Application No: A/70/21/HH
Site Address: 66a Arundel Road Angmering BN16 4LL
Description of works: Single storey rear extension & Velux to loft space

Thank you for your internet representation made on 14th May 2021 which has been recorded as no objection with the comments as follows:

Proposed Roof Plan

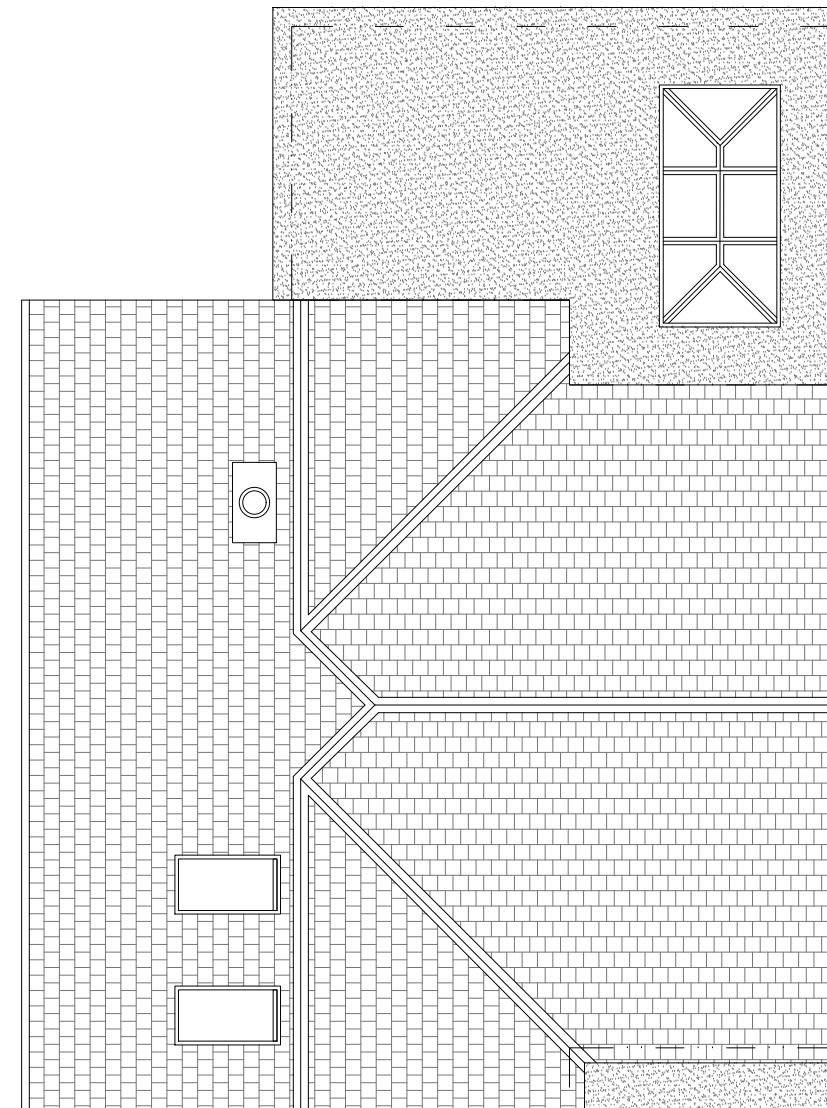
The Velux window should comply with any dark night skies policy in the NPPF, ADLP and SDNPLP
